## Letter of Intent

### Variance / Administrative Relief Request

**Property Address:** 2895 Walton Creek Drive

# Site Plan: Layout

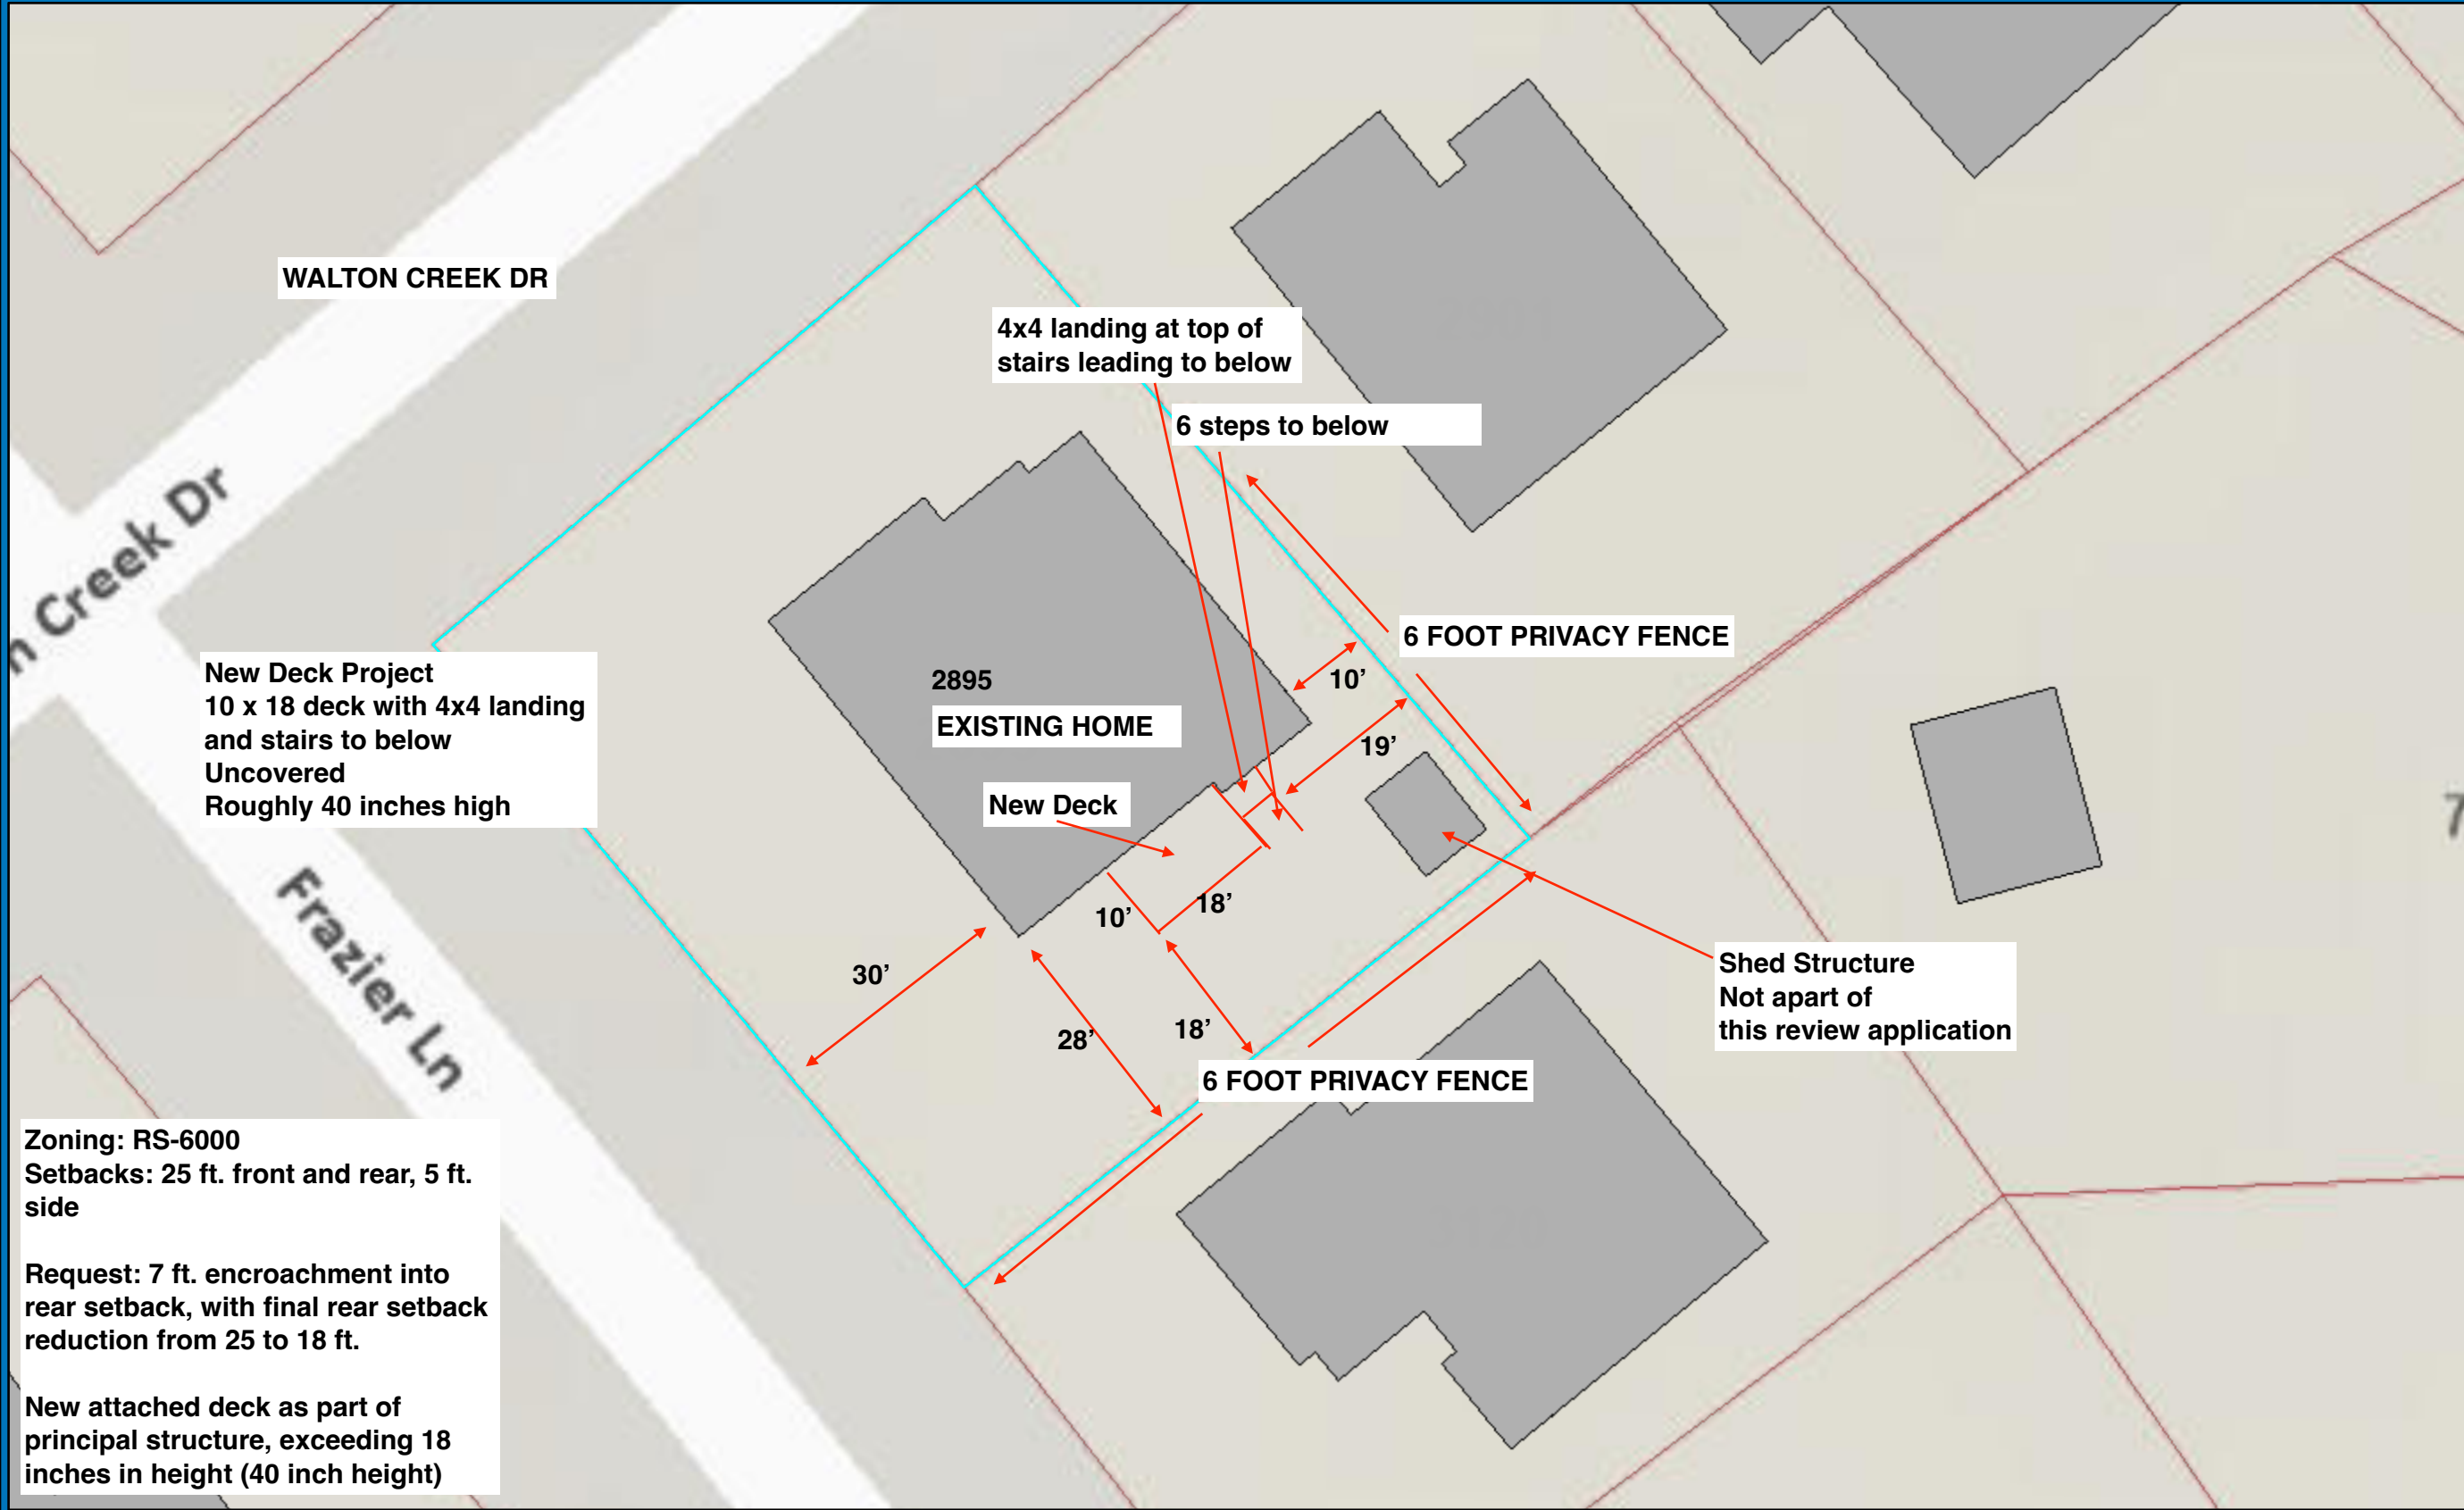
Please just add a label for this street that is not cut off: Walton Creek Drive

Please label distance to side setback

Label structure, dimension from property lines, and whether part of this application

label: fences, if any
